About the application

Application number: 2022/93731	
What is the application for?:	Partial demolition and alterations to convert public house to 5 residential unit
Address of the site or building:	Woolpack Inn, Whitley Road, Whitley, Dewsbury, WF12 0LZ
Postcode:	WF12 0LZ

DRAWING TITLE  
GENERAL ARRANGEMENT - PROPOSED

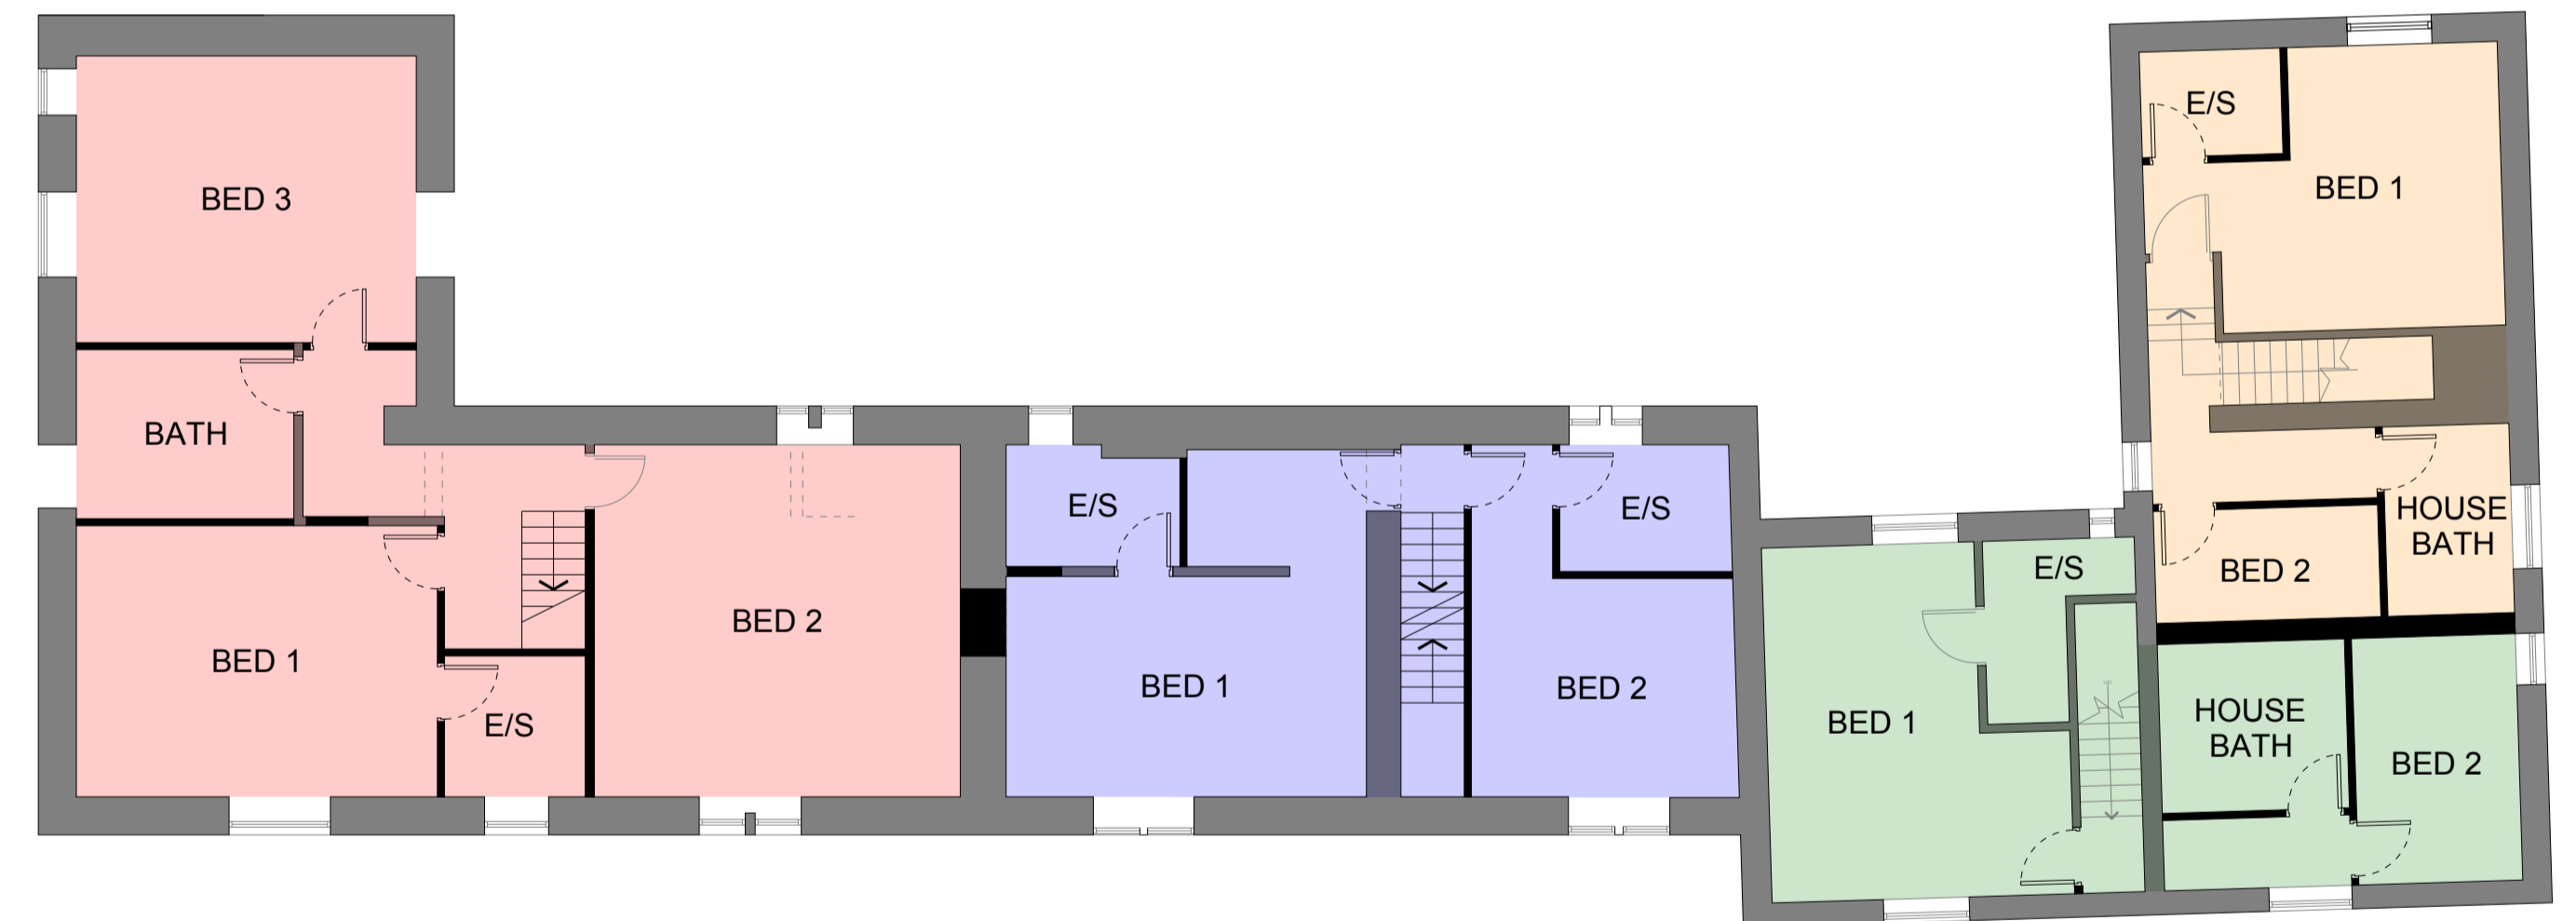
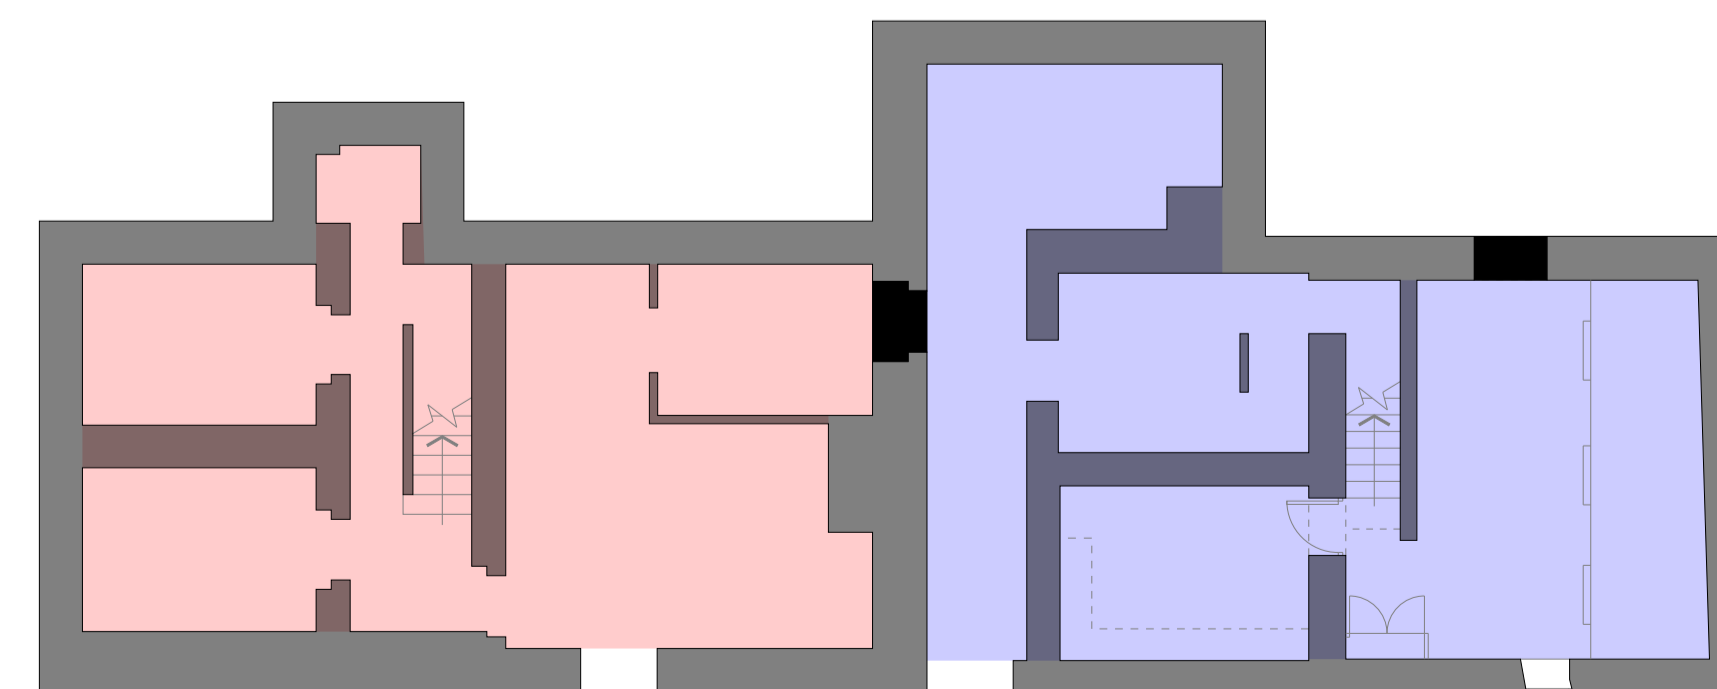
Type of comment: An objection	
Do you wish your comments to be published on the website anonymously?	Yes
<p>I object to the current application</p> <ol style="list-style-type: none">1. I believe there is covenants on the property2. The highway implication and limited parking will have adverse effects on whitley road and scopsley lane3. The pub and accomodation has potential to be profitable inspite of the current climate . Opportunities have been missed4. The property has not been offered on the open market5 There is history attached to the pub and the Inn6. Alternative development could be considered to include housing development as well as a smaller pub and accomodation7. It has not been marketed or developed or given any real business focus in recent years8. It does not rely on public transport. It is and always has been a destination pub with local support and passing trade too9. Signage is a poor excuse for not being found in this world of social media . Plus a new sign10. The food offering , opening hours , events and local engagement have been massively lacking recently months to the point of earning a very bad reputation <p>Whilst i appreciate that public houses are closing at a high rate and the cost if running a pub is huge along with econimic pressures, i still feel there is miliage and opportunity in the village and area for a compromise and concerted effort to once again become profitable</p> <p>Regards</p>
